Date 16 January 2024
Our Ref 23/01500/FLH

9 West Gardens, Ewell, Surrey

Widening of existing dropped kerb. New front porch, roof extension to accommodate habitable space incorporating rooflights. Alterations to fenestration.

Thank you for your planning application which was received on 25 December 2023. We have checked the application and have found that it is invalid. This means that we cannot currently accept it for registration. The following details must therefore be submitted for the application to be registered:

DRAWING TITLE:
Existing & Proposed
Site Plans

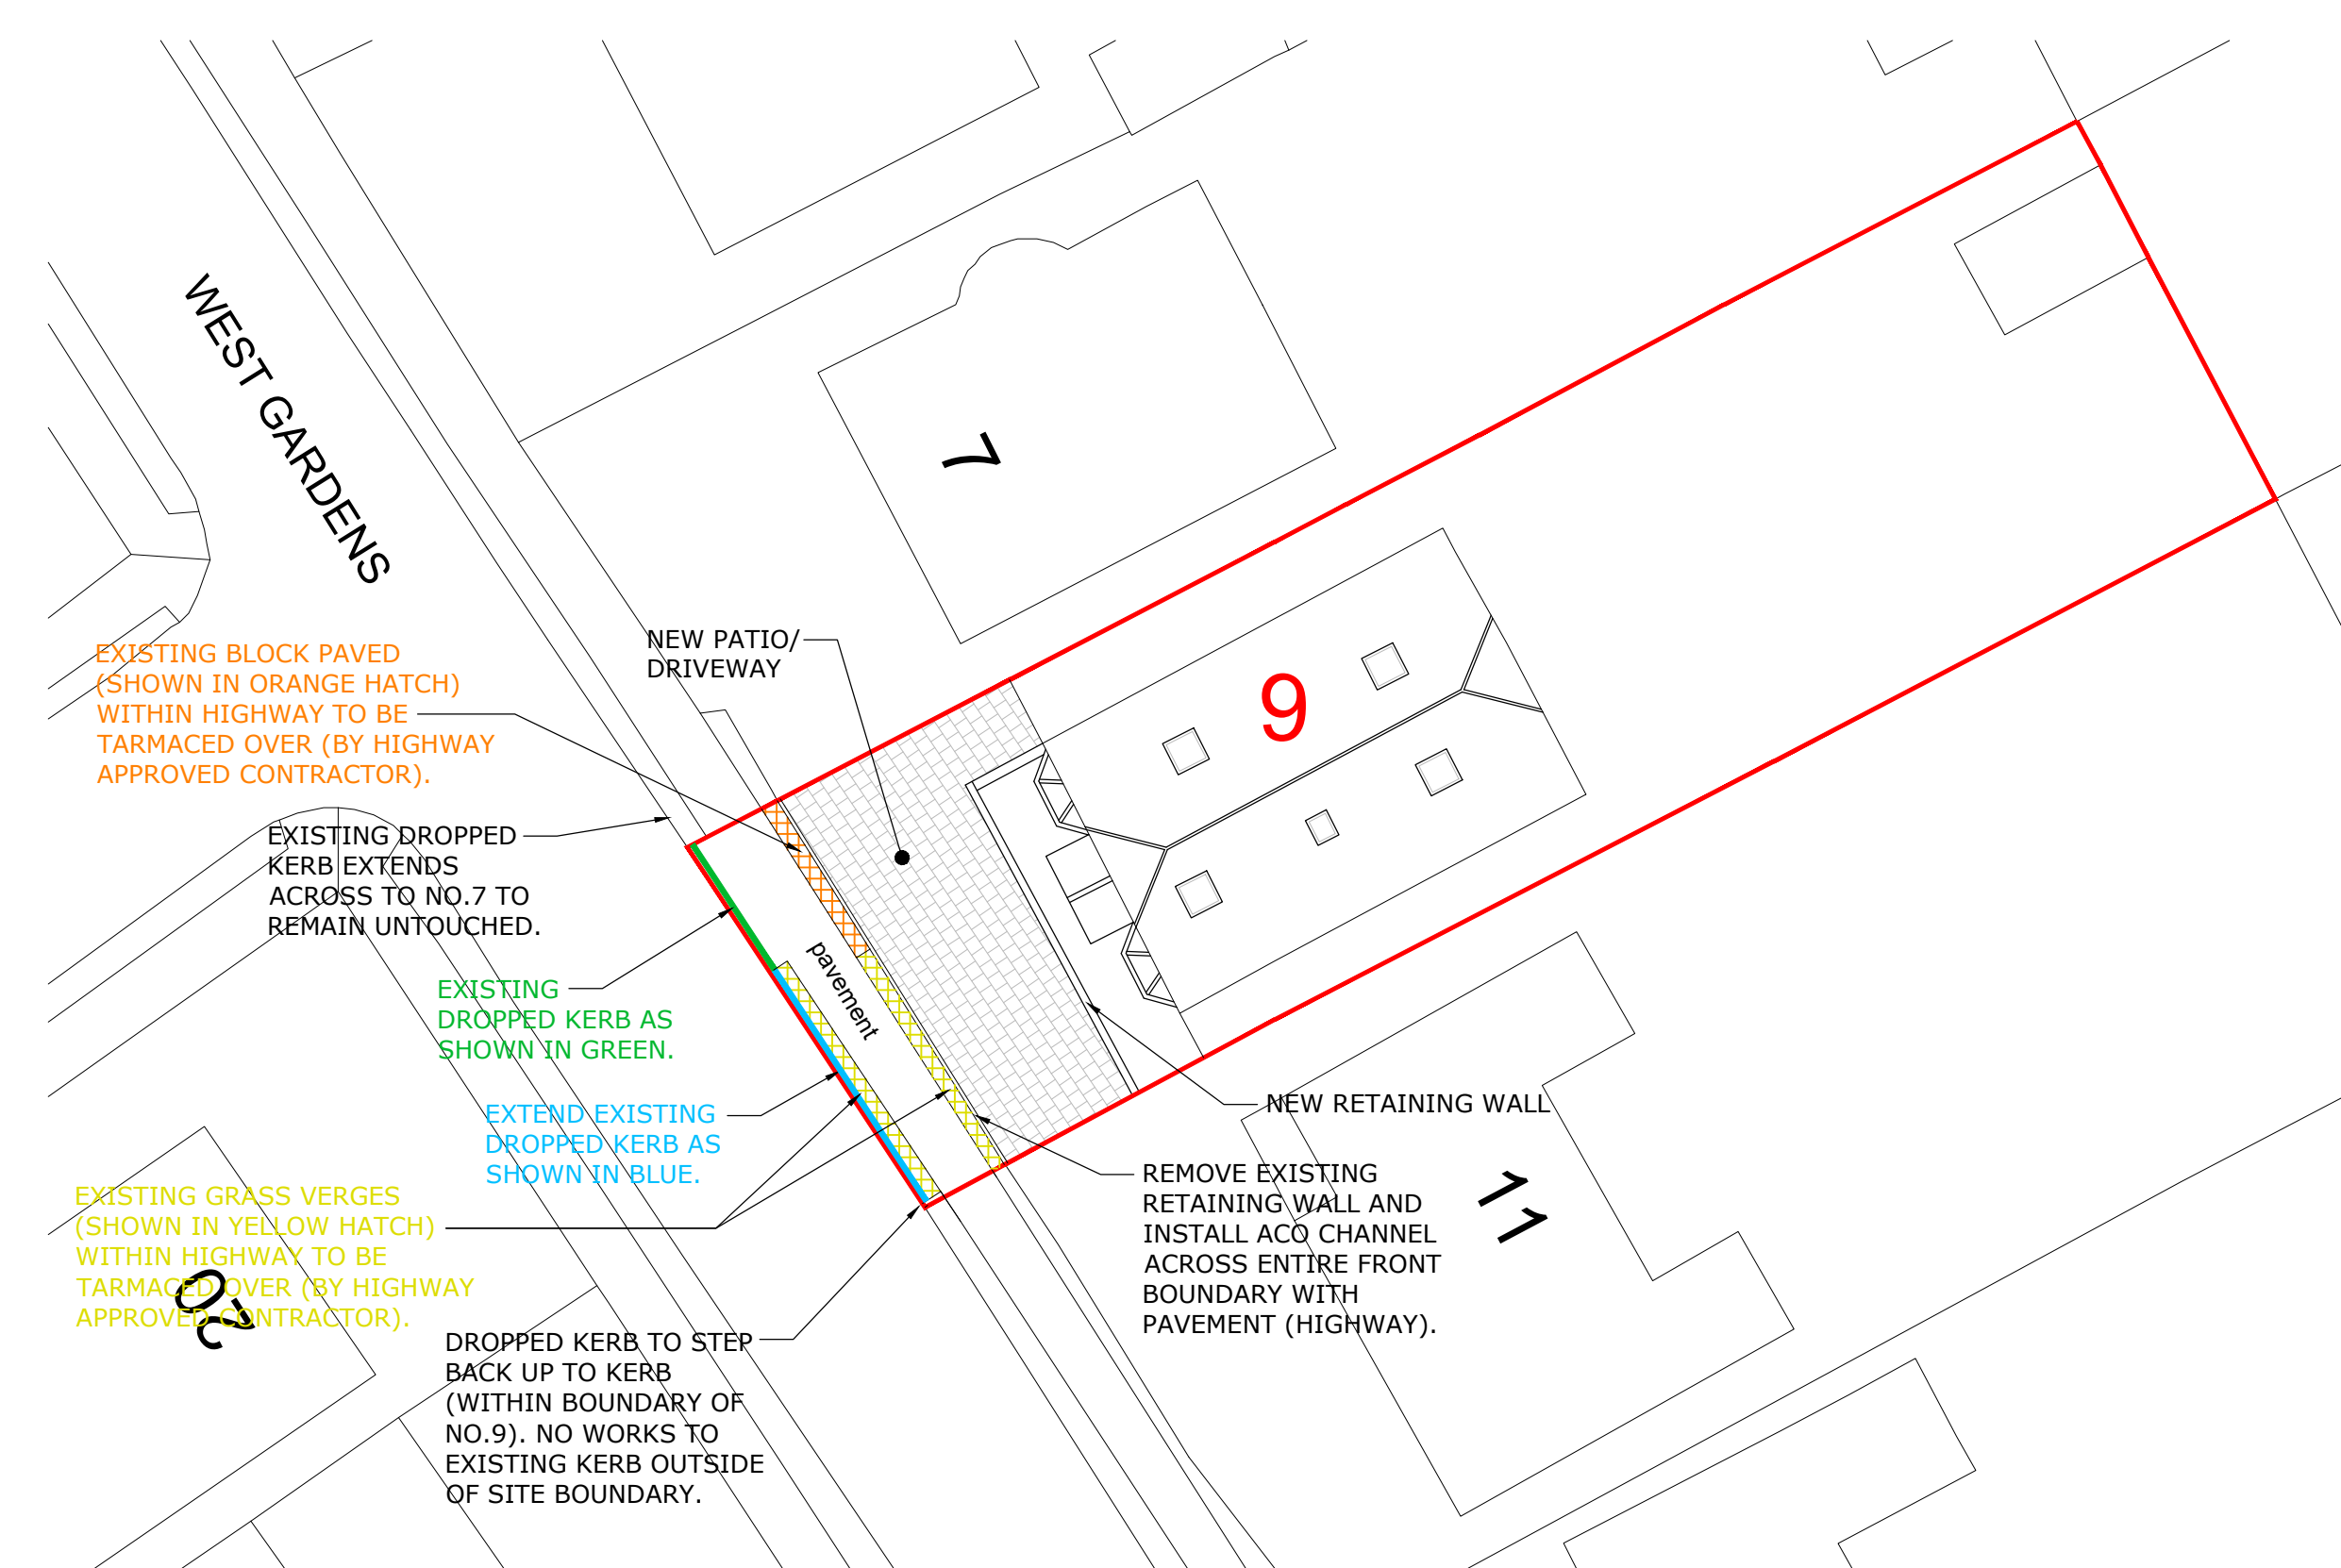
5 EXISTING AND PROPOSED SITE PLAN - Please submit an existing and a proposed Site Plan at a scale of 1:200 or 1:500 showing the proposal clearly differentiating from the existing (e.g. hatched) and its relation to the site boundaries, any other existing buildings on site and the neighbouring properties. The existing site plan is to show the current situation and the proposed plan is to show the proposed situation. Specifically, please ensure the plans incorporate the pavement and the dropped kerb.

DRAWING No: 1179-005
REVISION: P1

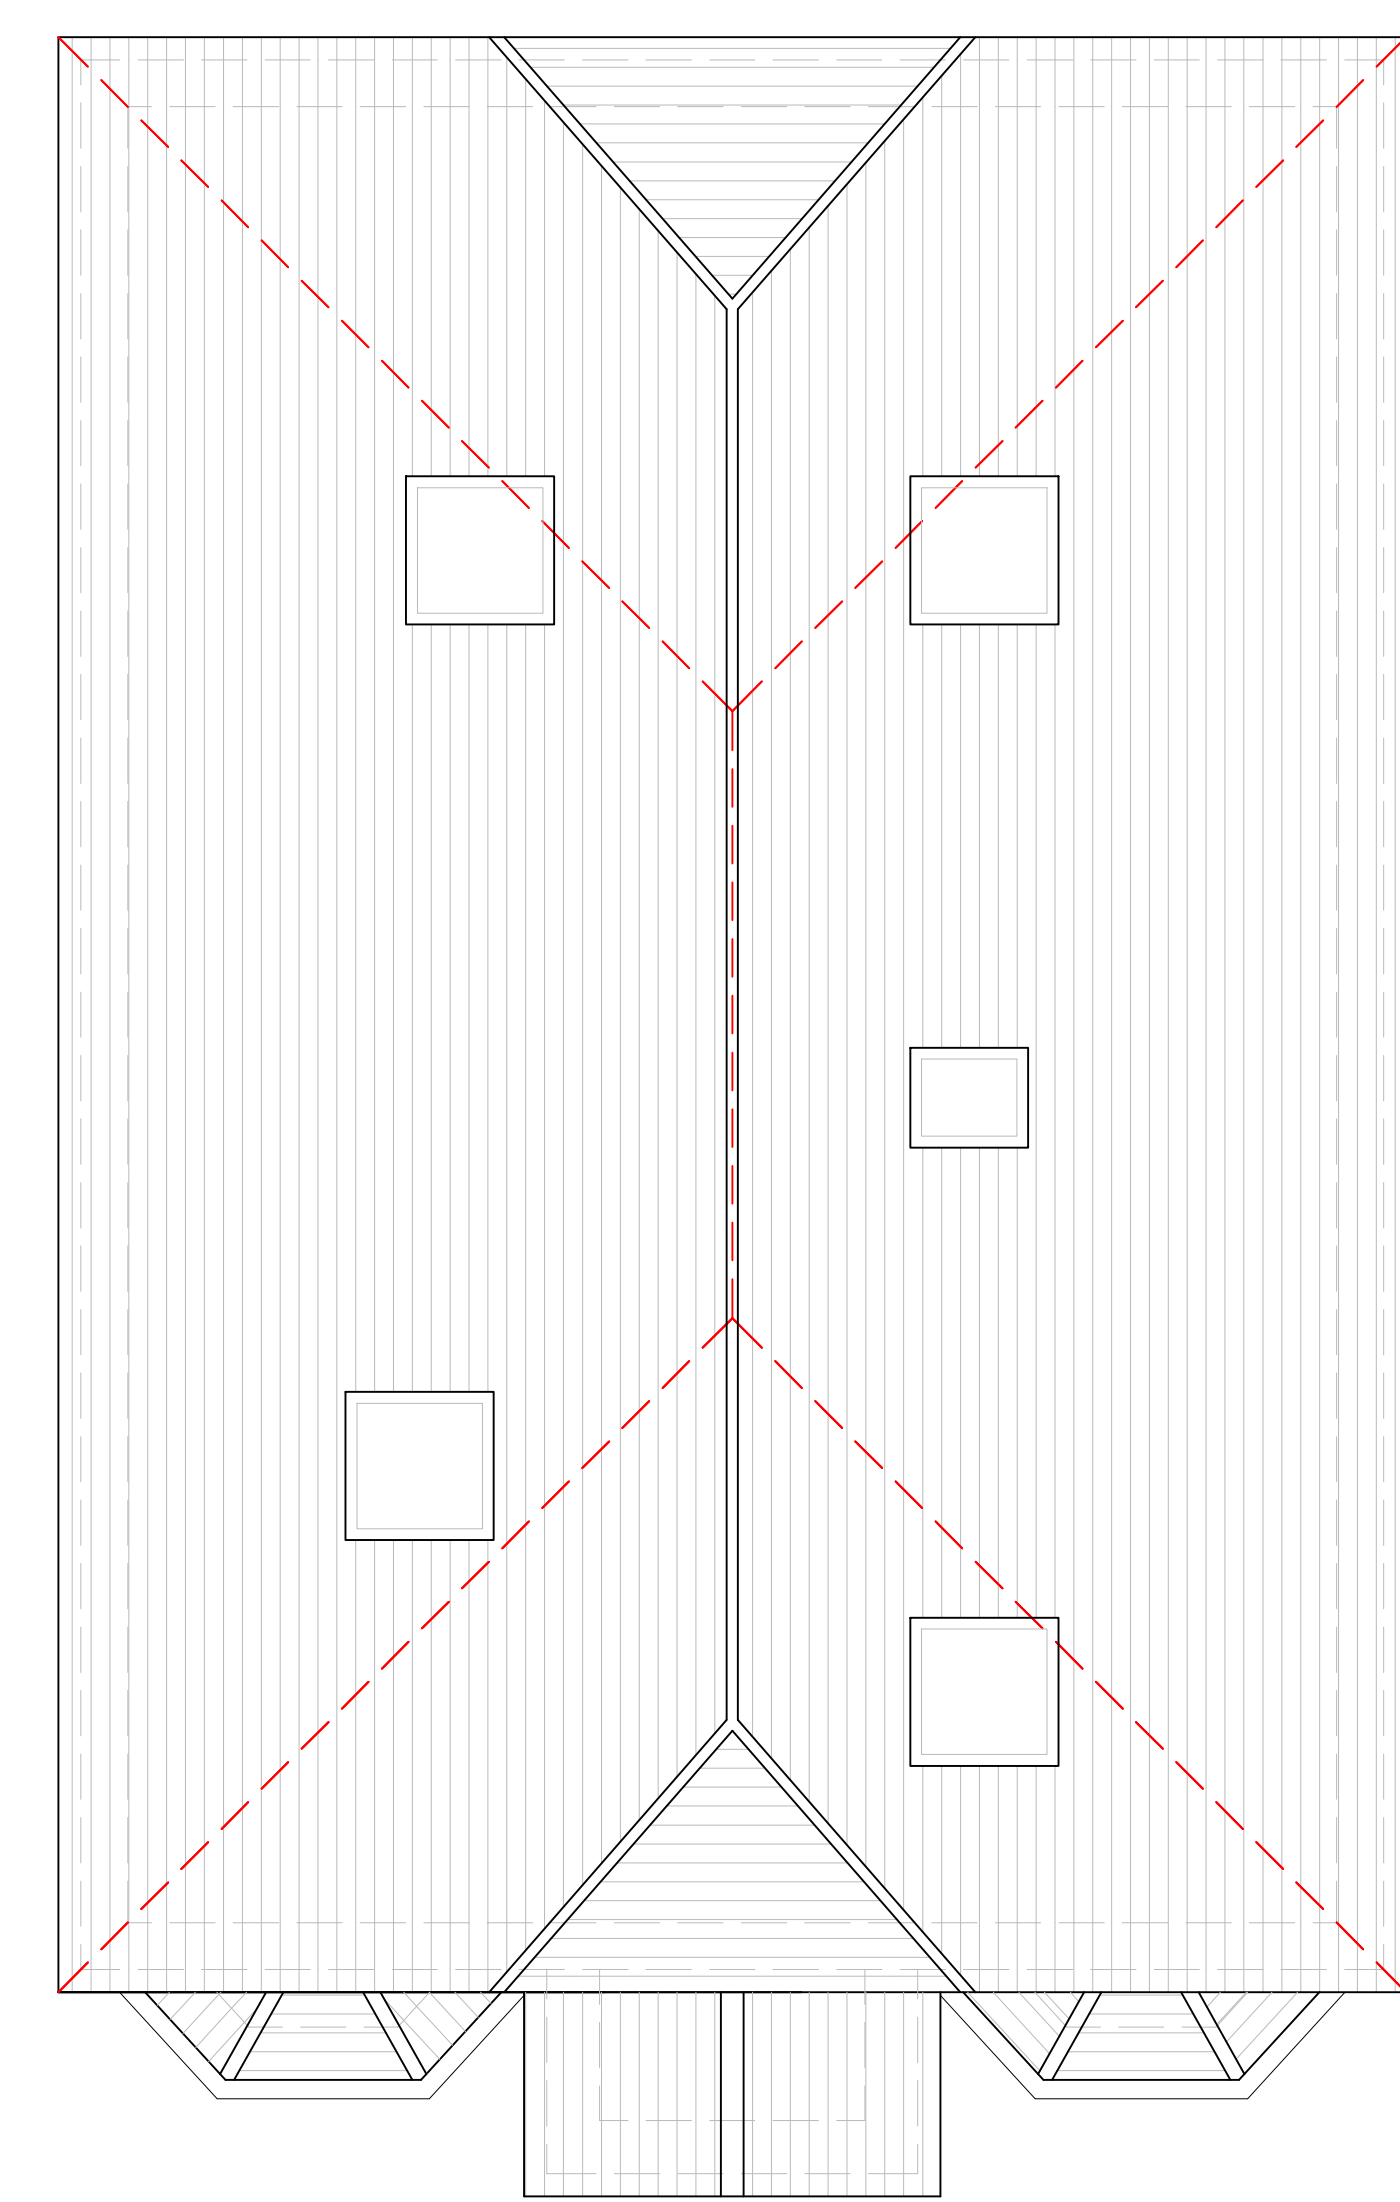
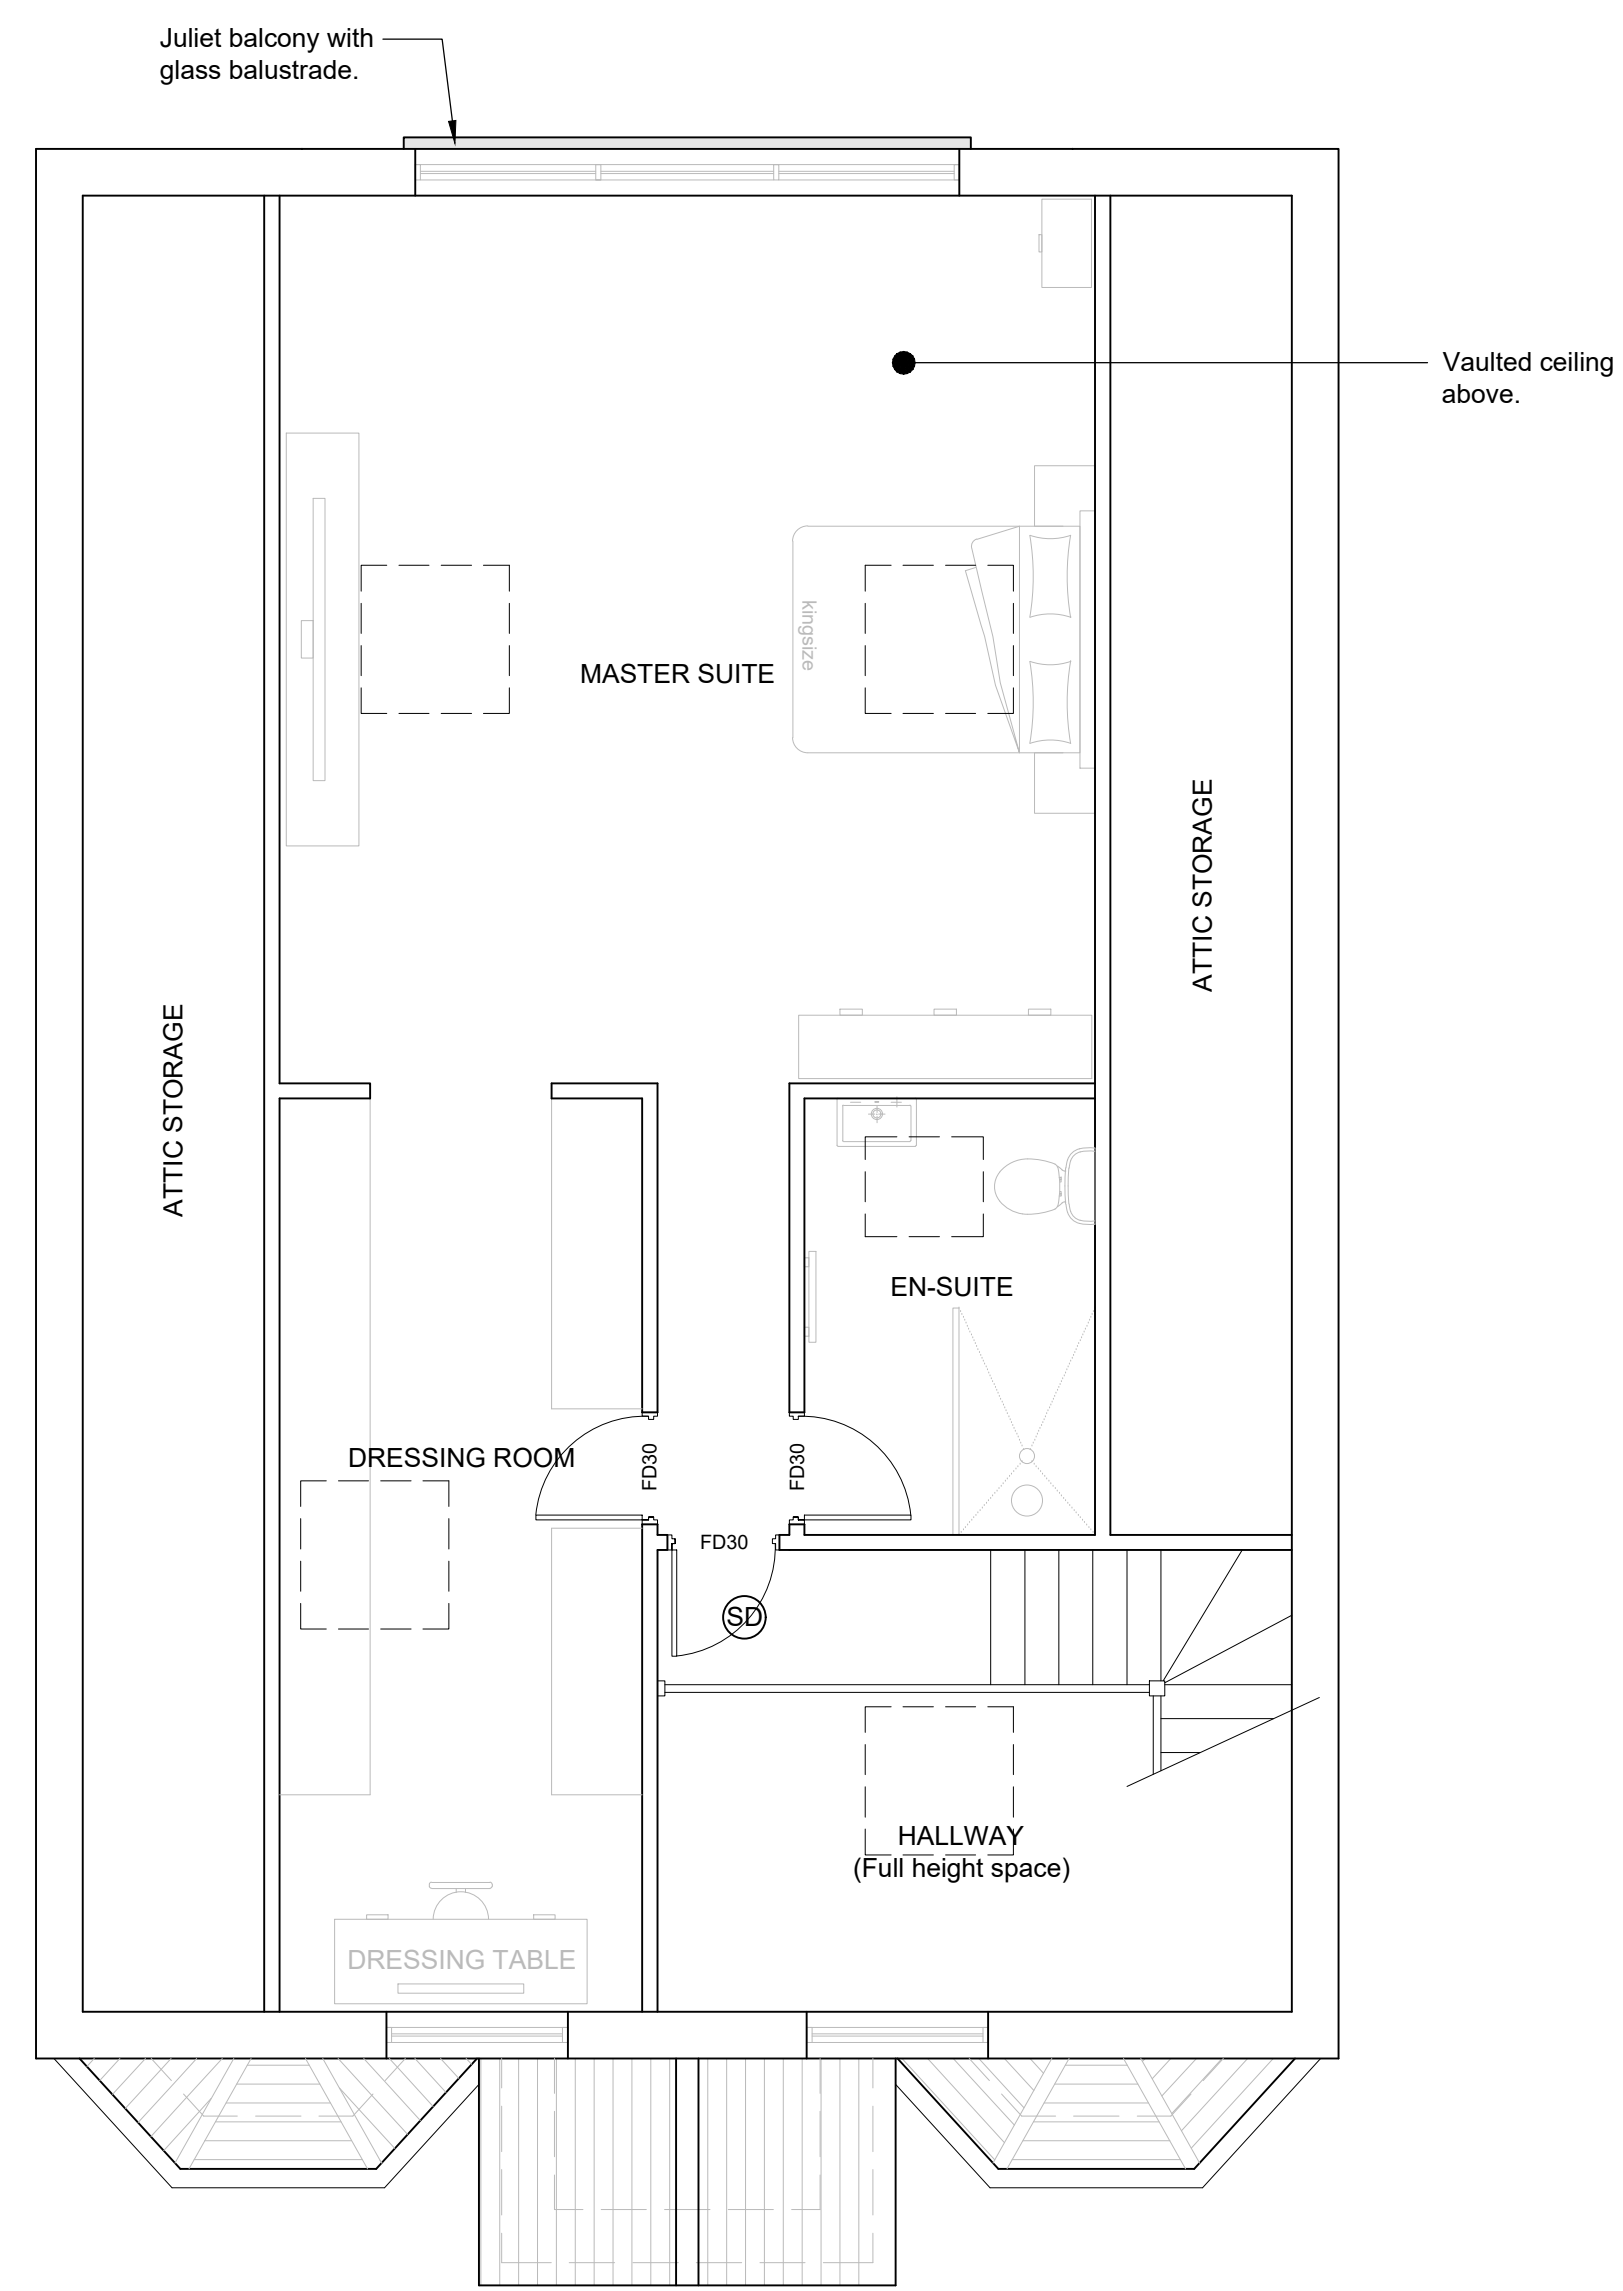
1 Drawing No. 1179-005, Titled Proposed Layouts - The individual drawings on the drawing are detailed as "Existing". Please amend and re-submit to planningsupport@epsom-ewell.gov.uk
